OUT20/14269

**200 Aldington Road Industrial Estate (SSD-10479) - EIS**

I refer to your email of 16 November 2020 to the Department of Planning, Industry and Environment (DPIE) Water and the Natural Resources Access Regulator (NRAR) about the above matter. The recommendations below are provided by NRAR.

Figure 4: Validated watercourses within study area

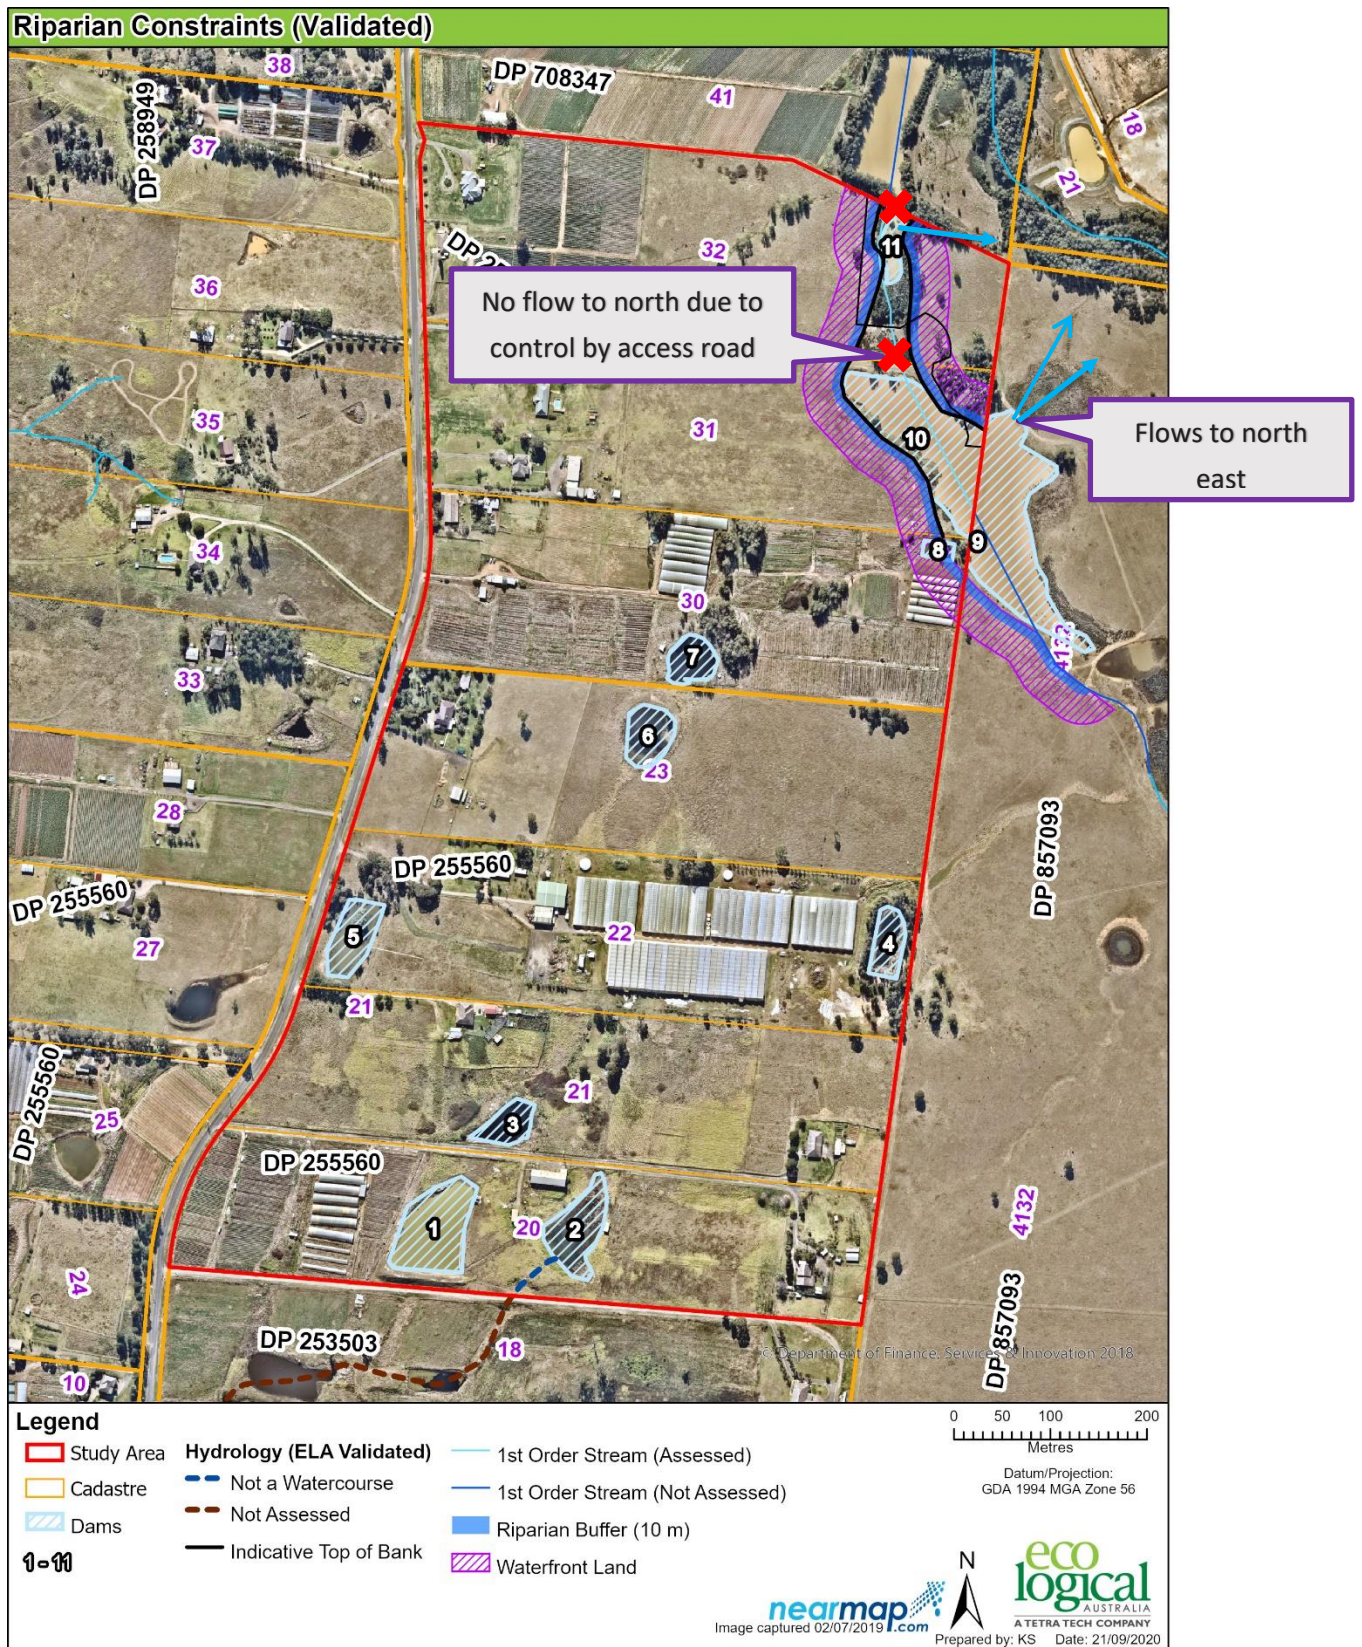
**Comment** - NRAR notes that the site area contains a 1st order watercourse with an online dam that is proposed to be reconstructed into a riparian corridor and watercourse channel.

Due consideration of the NRAR Guidelines should include the provision of a riparian corridor re-establishment plan for review prior to approval to assess its suitability against the NRAR Guidelines. NRAR notes that the established corridor must not contain non-riparian features.

3. Design the watercourse reconstruction to connect into upstream and downstream sections of the existing watercourse, and not limit any connectivity in the area. The reconstruction should also align with the Mamre Road Precinct Structure Plan (June 2020).
4. Establish a Vegetated Riparian Zone (VRZ) in all areas identified in the Mamre Road Precinct Structure Plan – June 2020. The VRZ should be established into a 10 metre riparian corridor, measured from top of bank either side of the channel, and subject to a Vegetation Management Plan (VMP).

Figure 16: Proposed development footprint

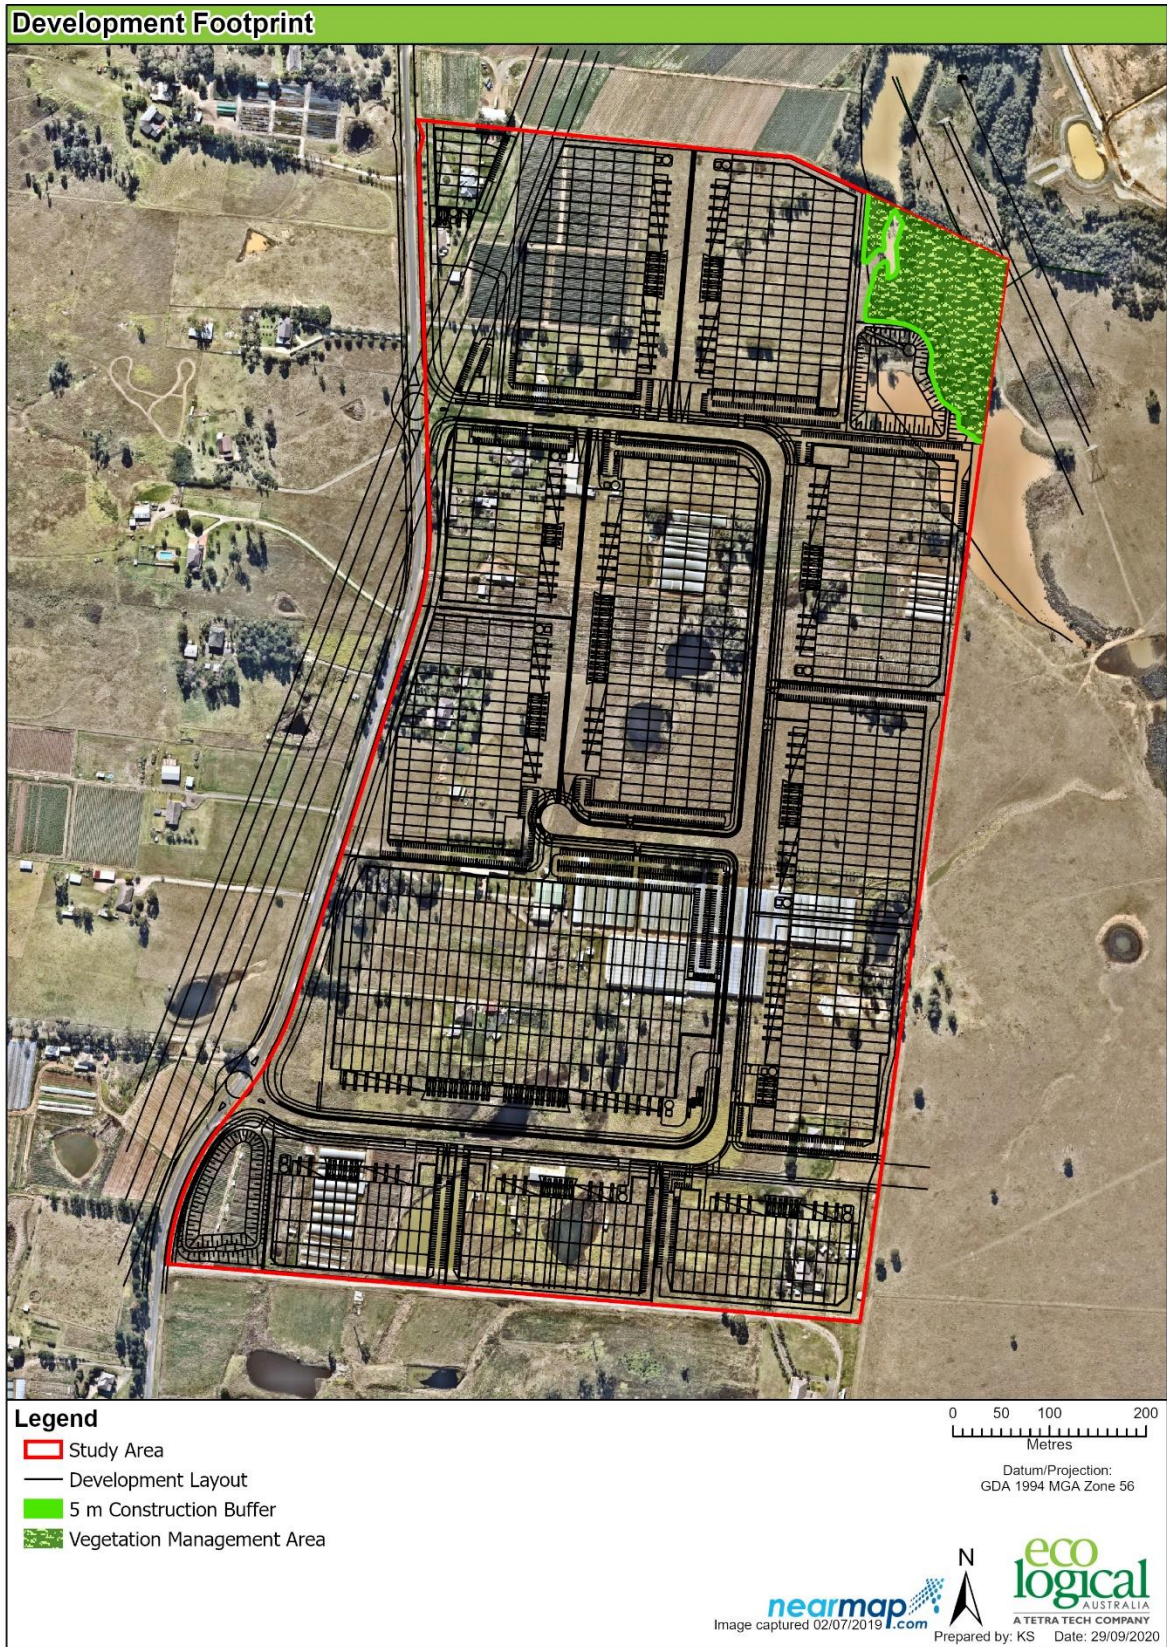
5. Assess post-development impacts on the watercourse and the adjacent wetland area.
